# Householder Delegated Report

<b>Application No.</b>	24/01489/F
<b>Site Address</b>	17 Read Place, Ambrosden, Bicester, OX25 2BH
<b>Proposal</b>	Single storey side extension, flat roof, to add a bedroom for disabled person

Proposed Side Elevation
1:100

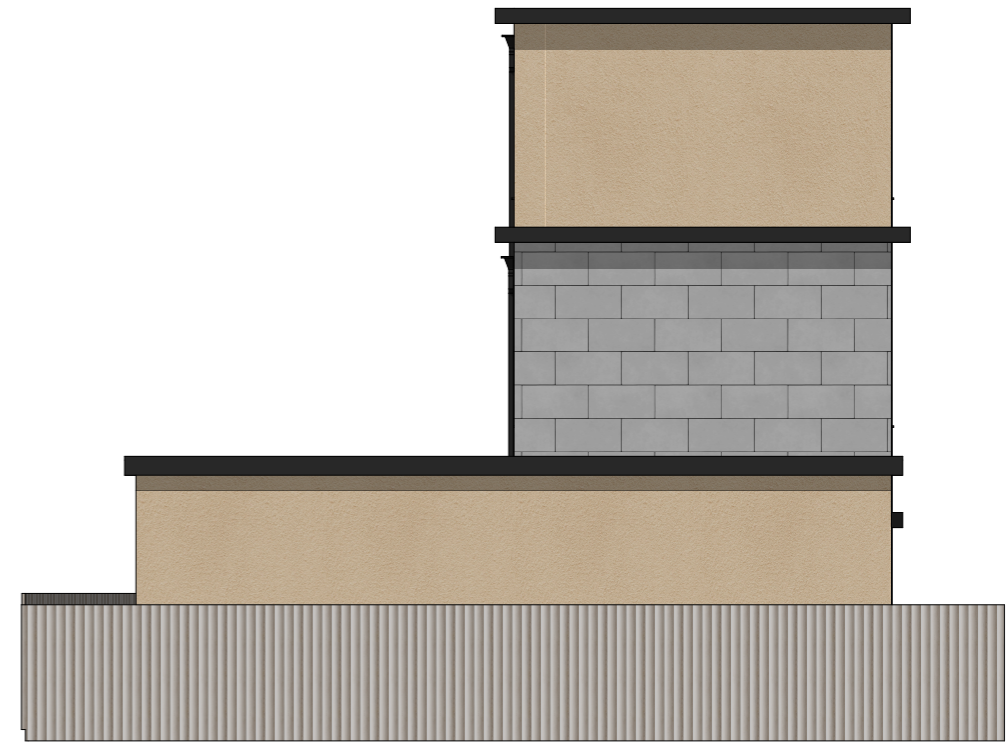
The proposed development would be located on higher ground level, further the increased height of the development extending out full width of the shared boundary with no. 15 Read Place, would tower over the neighbouring property and appear overbearing. In addition to this upon site visit it was established the windows serving the kitchen and living room would be affected by the proposed development both of which are habitable rooms the proposal would therefore have an impact on the residential amenities of the neighbour due to substantial loss of light and overshadowing.

Proposed Site Layout
1:500

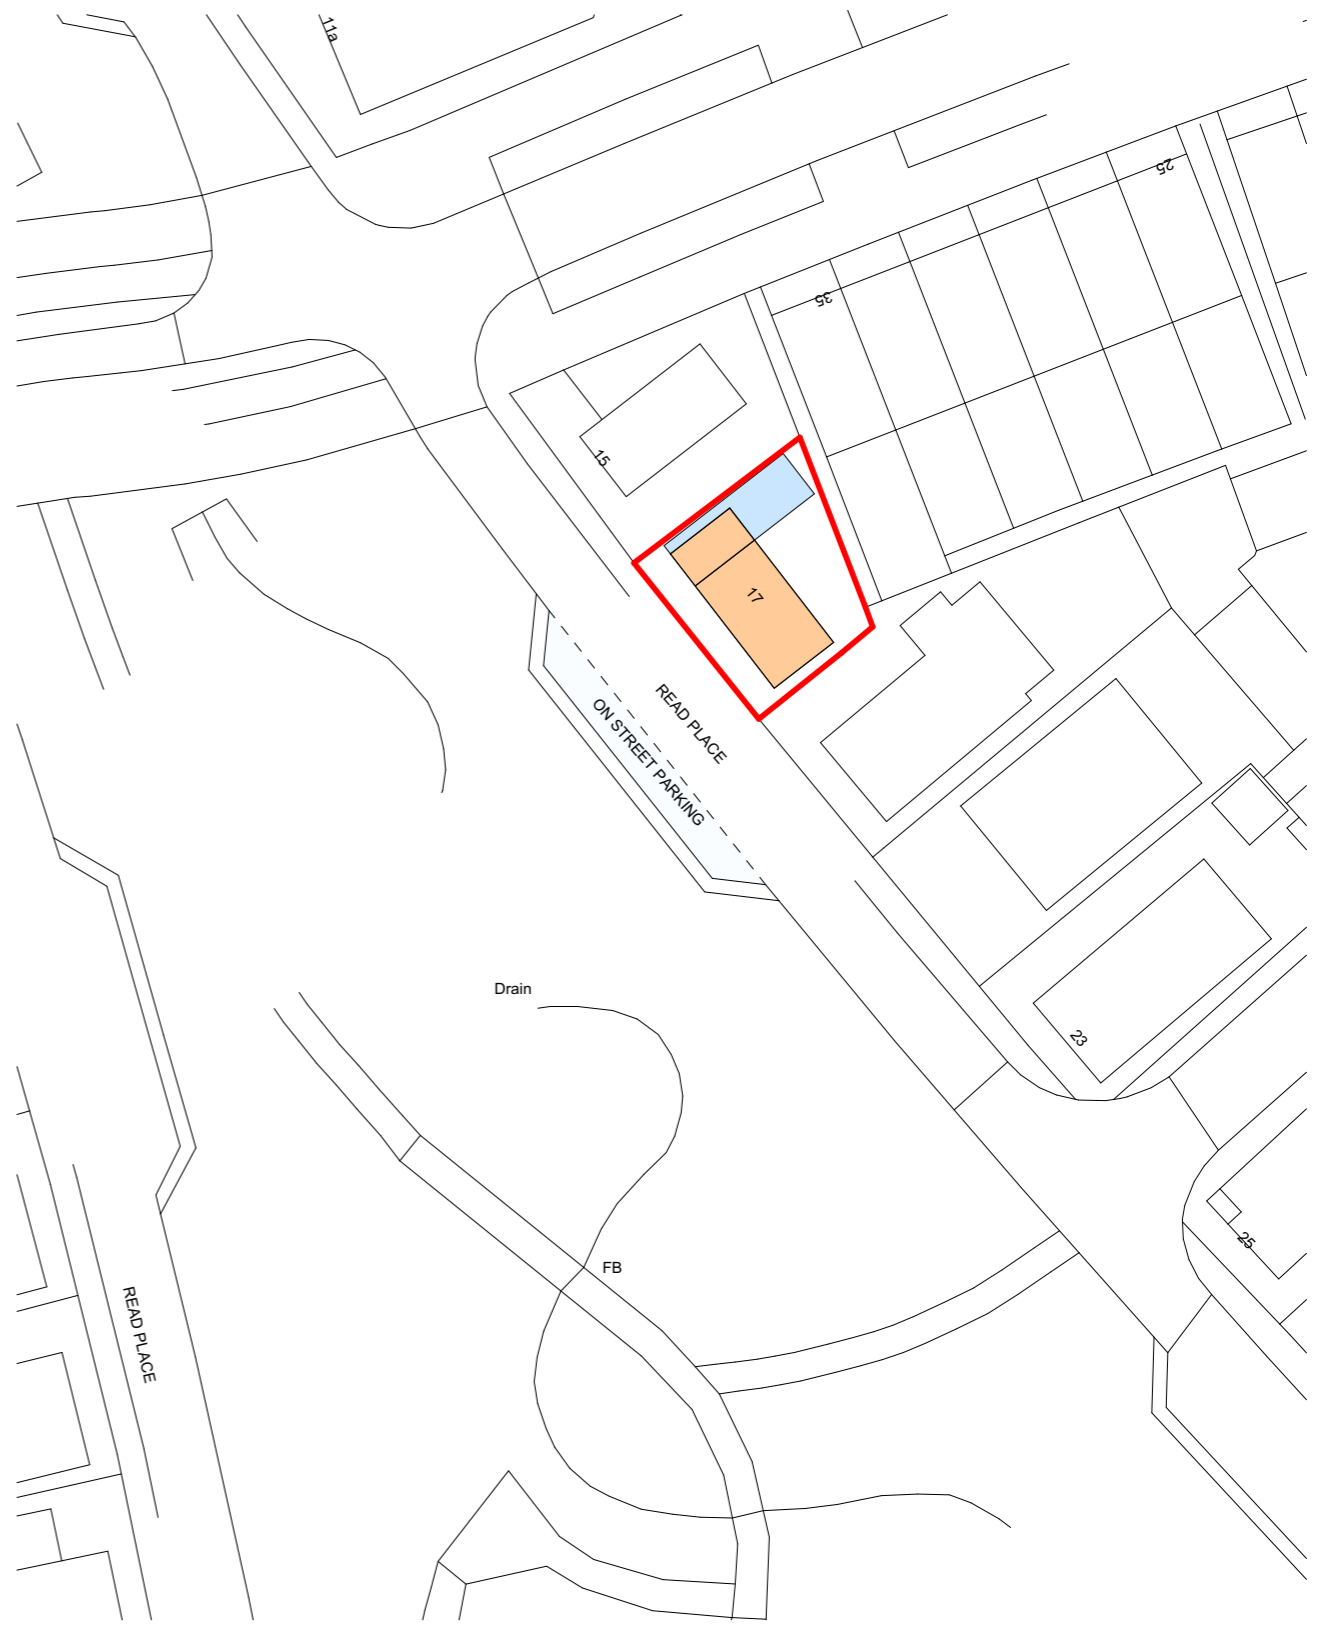
b) If the parking area is to be altered, does the proposed construction accord with the OCC standard?		NA
c) Does any new <b>access</b> proposed meet highway standing advice/OCC response (width, visibility splays etc)?		NA
<p><i>Comments (if any):</i></p> <p>The application site currently has a car port that is the only car parking space for the site. The proposed works would result in loss of parking space. Oxfordshire County Council's Parking Standards for New Developments outlines that a dwelling with 2-3 bedrooms should provide 2 on -site parking spaces. The proposed development would not adhere to this guidance. Further to this, Oxfordshire County Council, as the Local Highways Authority, has objected to the granting of planning permission.</p>
